Application number: 2024/90769	
What is the application for?:	Erection of one detached dwelling and associated works
Address of the site or building:	adj, 27, Riley Park, Kirkburton, Huddersfield, HD8 0SA
Postcode:	WF4 5NF

Type of comment: An objection	
Do you wish your comments to be published on the website anonymously?	No
I am writing to object to this planned development on the grounds of development site instability, visual and residential amenity, trees and flood risk. Instability of Site I have serious concerns regarding the stability of the banking on which this proposed development sits. It is clearly unstable and there is the potential of collapse and landslip. The building is proposed to be built very close to the 'cliff edge' of the banking. The proposed development being significantly larger than the previous application raises increased concerns about safety and stability of the land to be built on. The proposed development also now has a basement level which will require excavation into the banking. There is no scheme of works attached showing how this will be achieved and how the building will be constructed safely. The site is on an area of previous coal mining an

Boundary Treatments Plan
Scale: 1 : 200

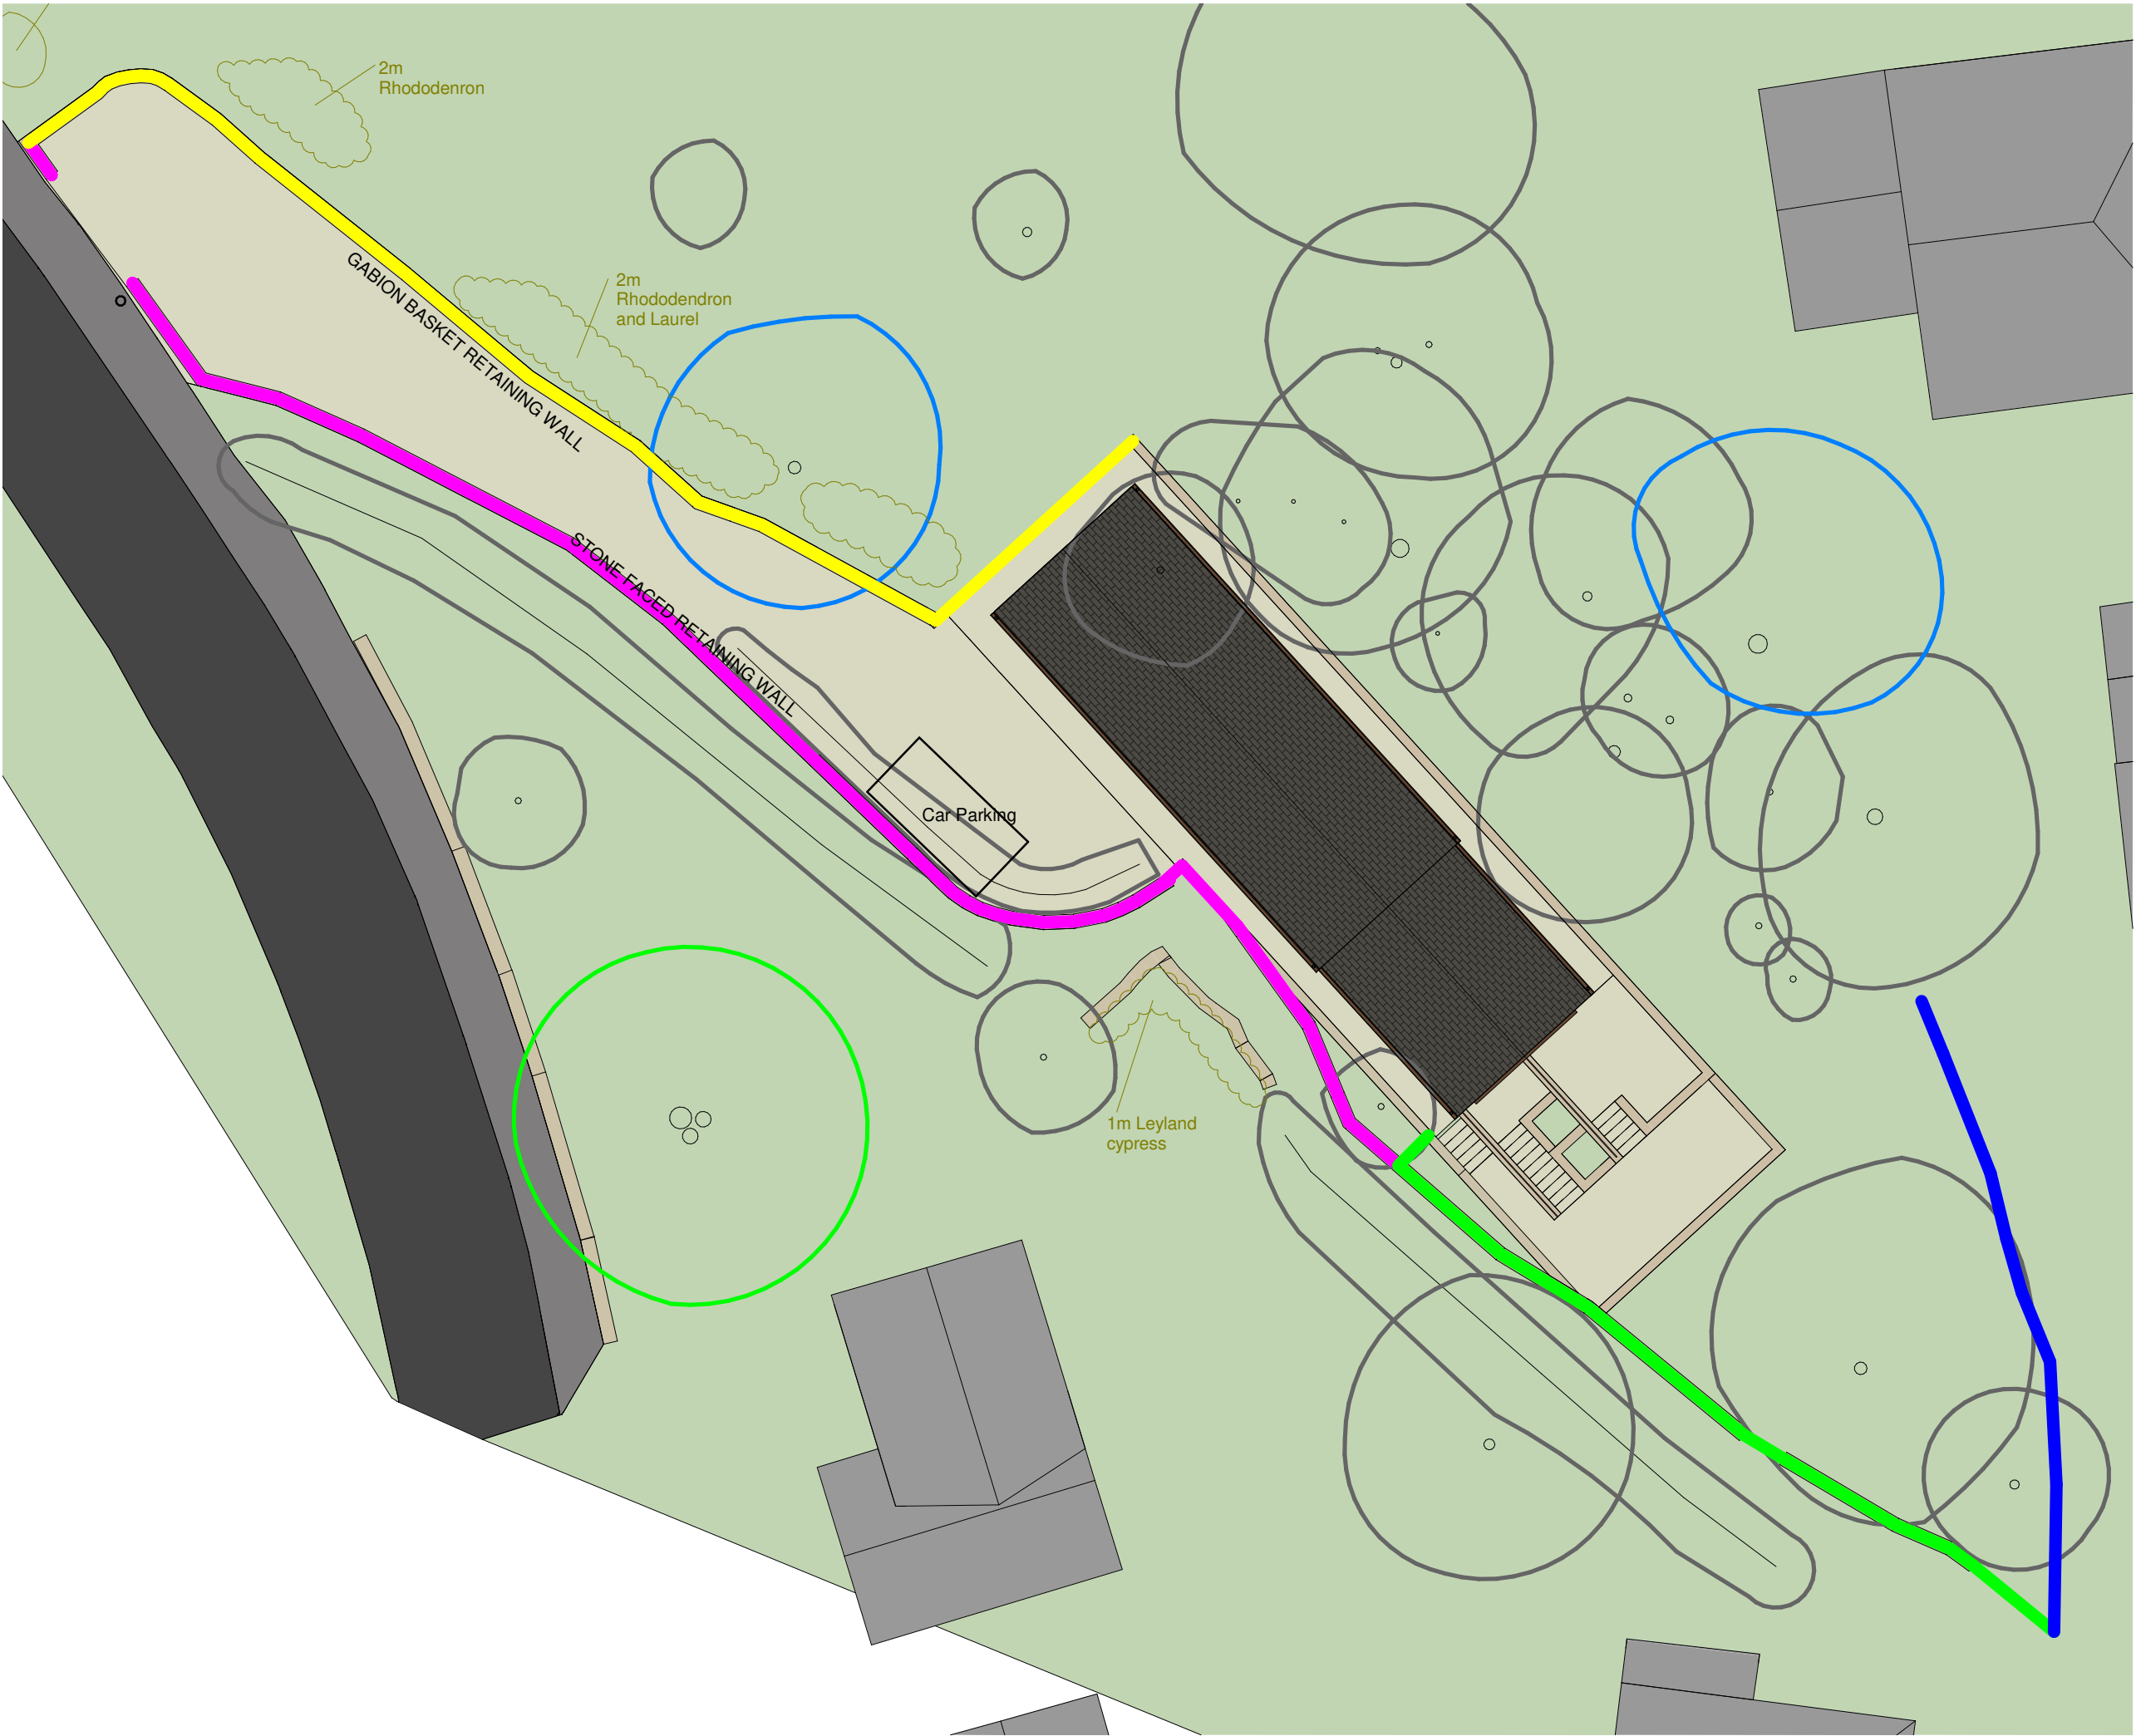
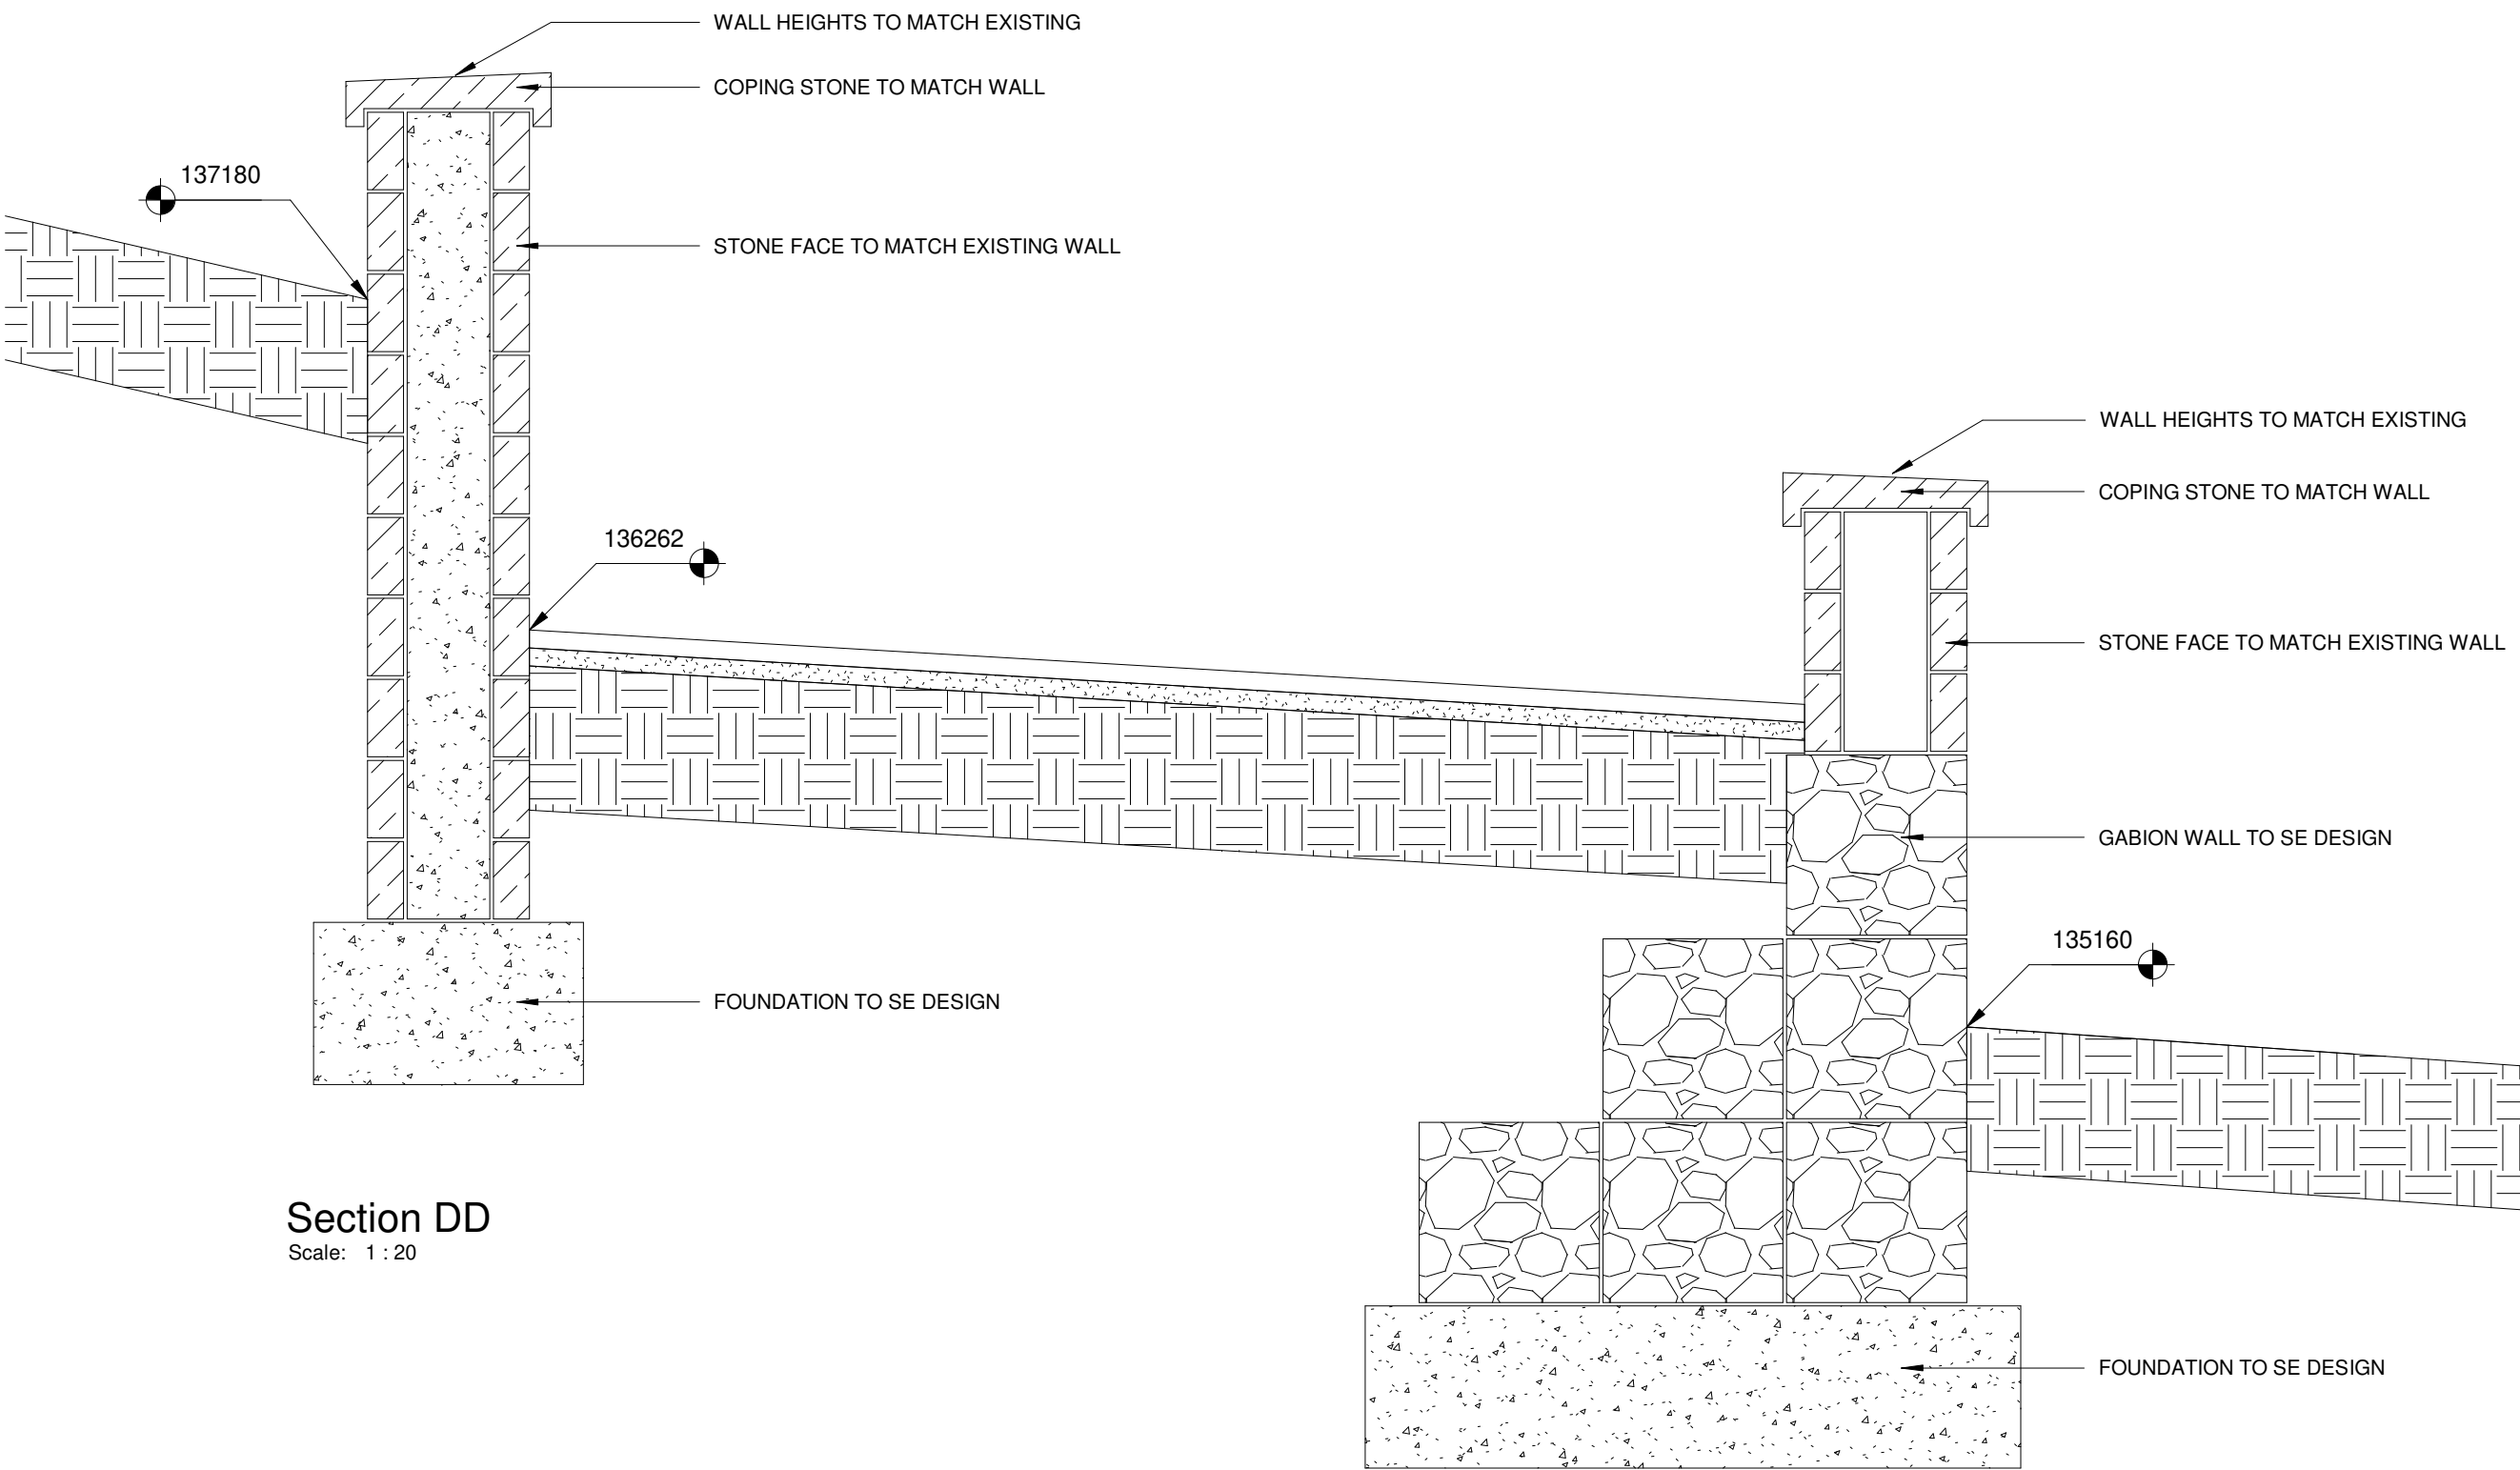
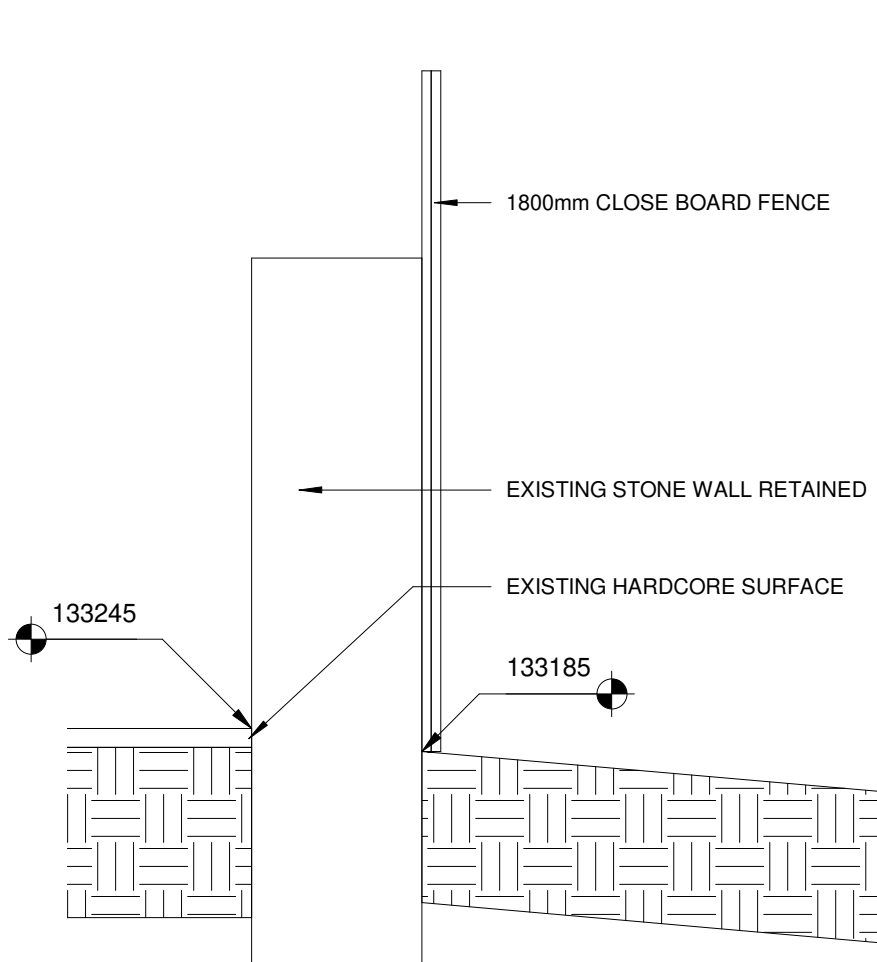
The proposed fencing of closed mesh with scaffold construction will resemble security fencing and again is not in keeping with the immediate area and will be visible and overbearing to neighbouring properties.
